Development Control
Ribble Valley Borough Council

App no: 23.0390

Address: Victoria Terrace Mellor Brow

Proposal: Erection of three dwellings with associated highway works (pursuant to variation of condition 2 (approved plans) on planning permission 3/2016/0092

Ground Floor Plan
1:50 Scale

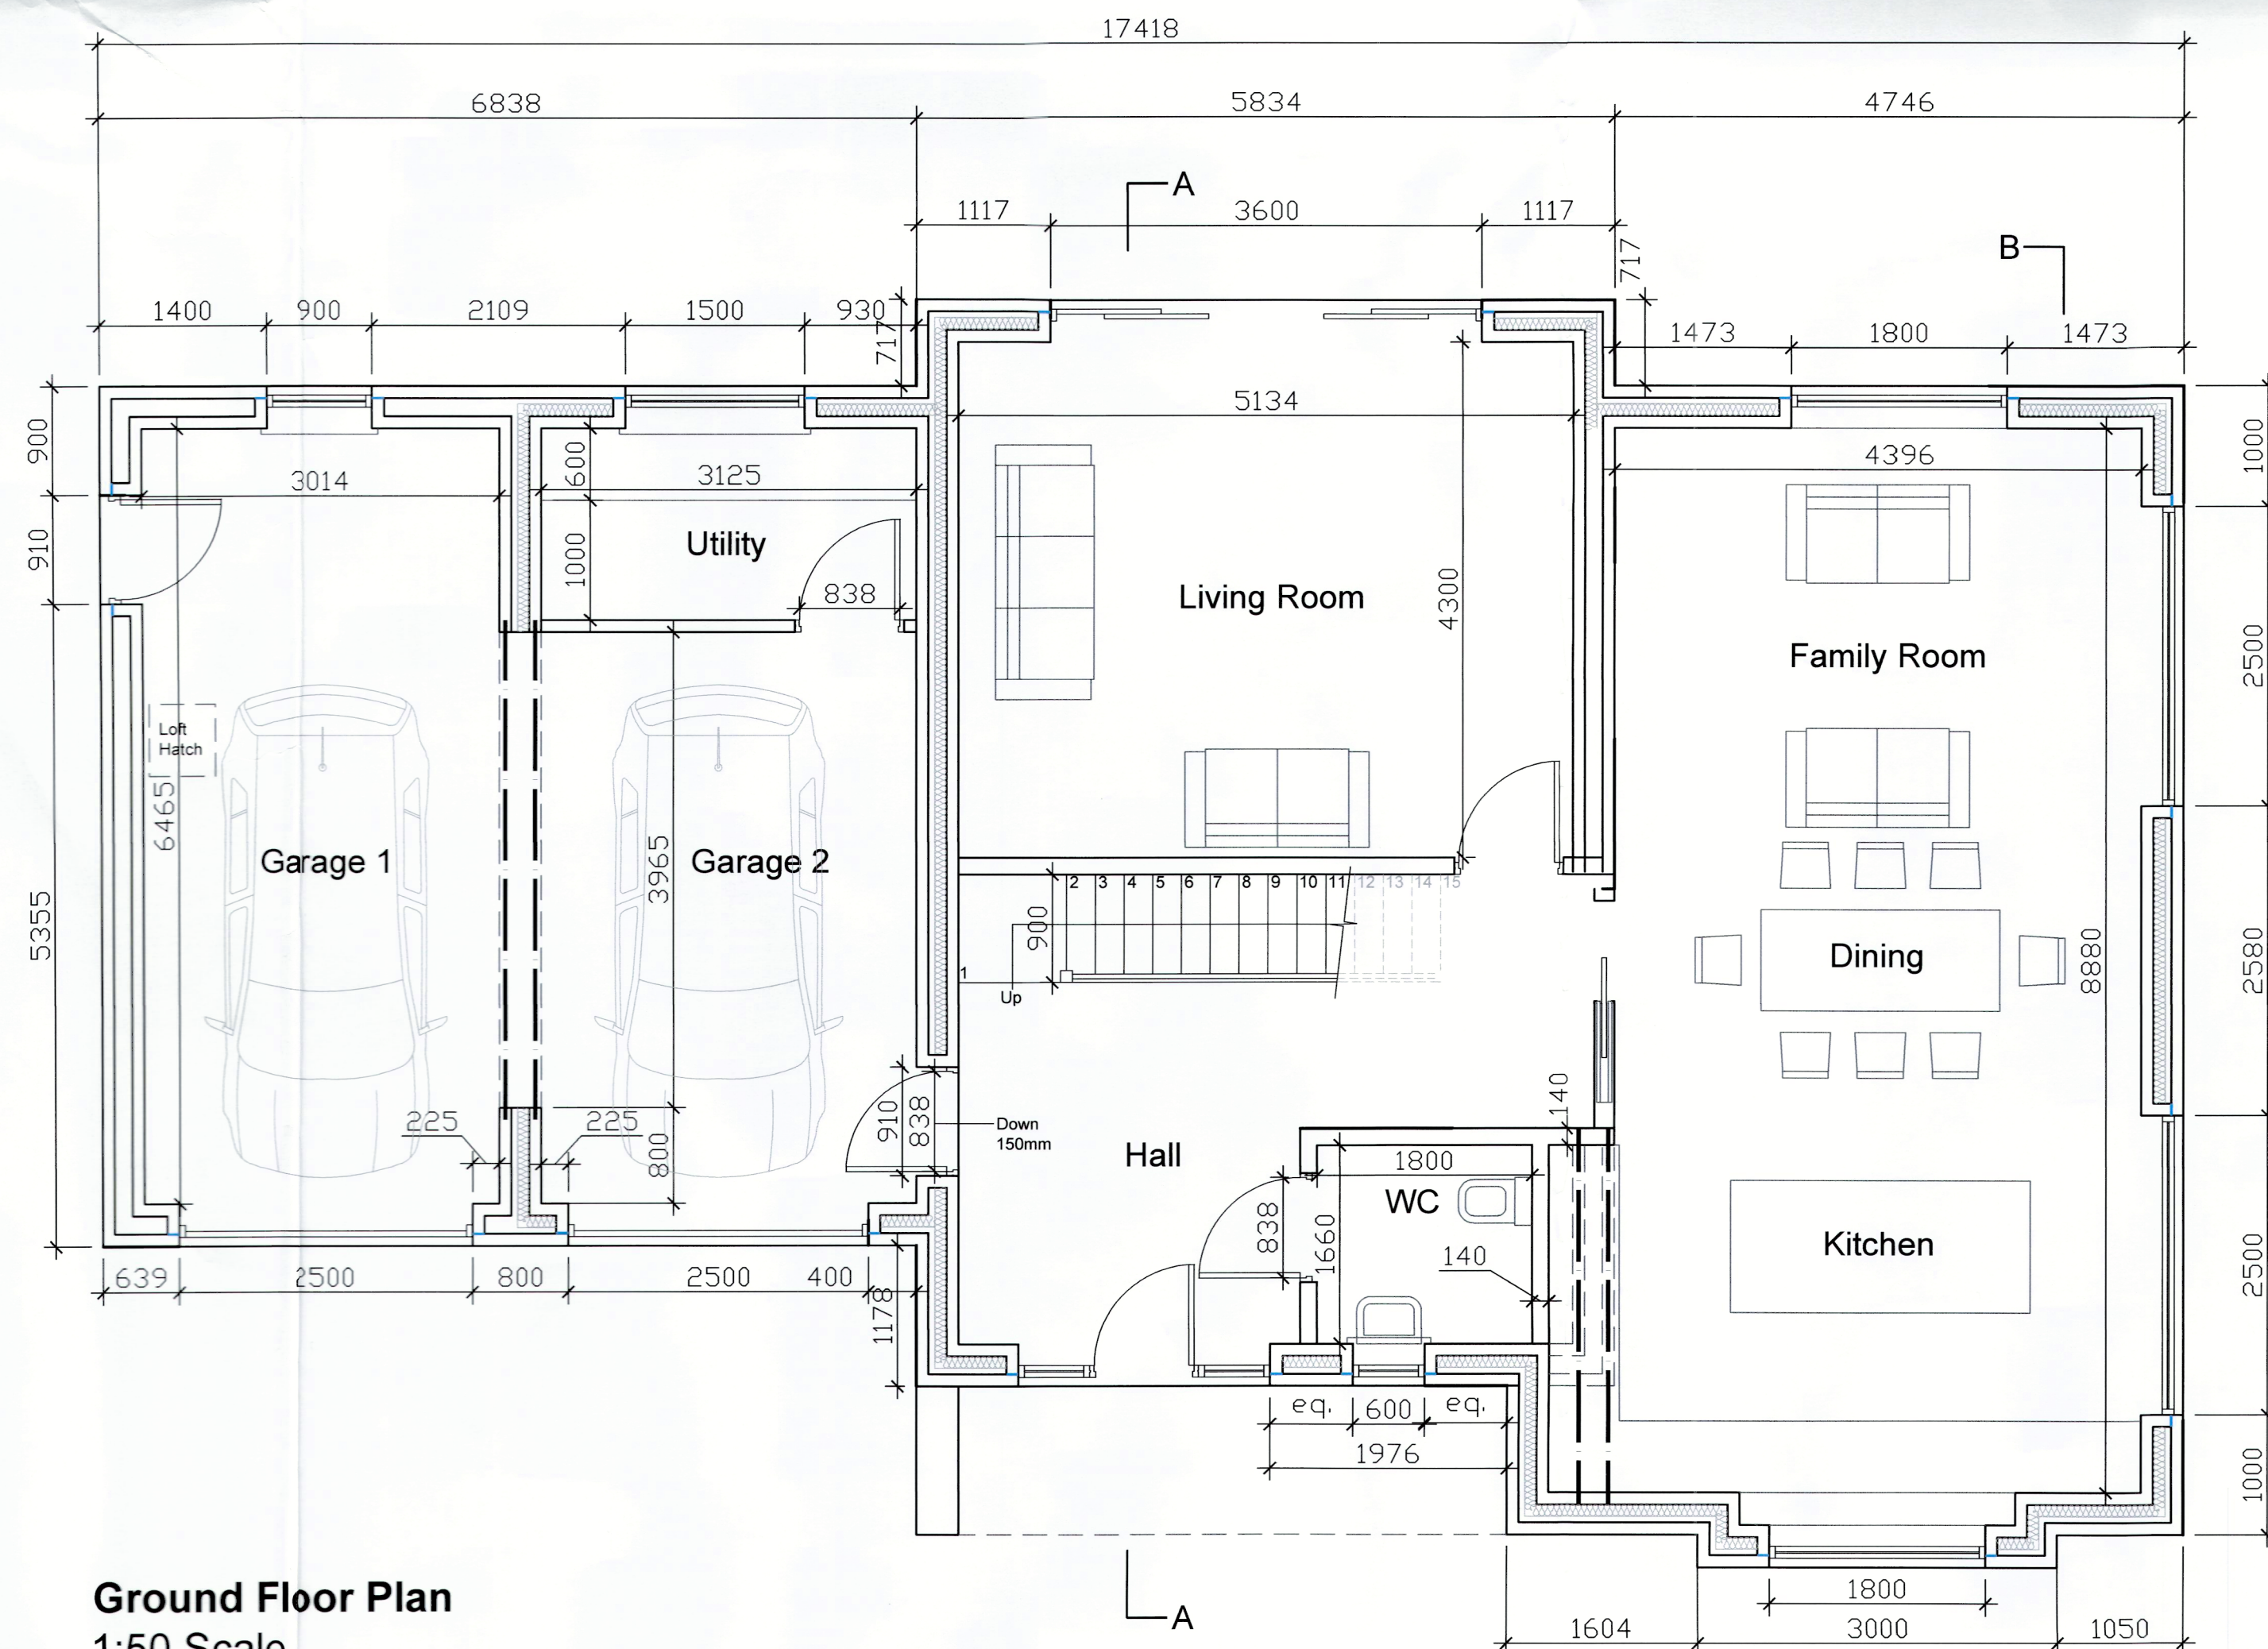
House type B is a 5-bedroom dwelling with double integral garage. The first garage space exceeds the 3m by 6m internal dimension however the second space measures 4.8m long which is below 6m and will not count as a parking space.
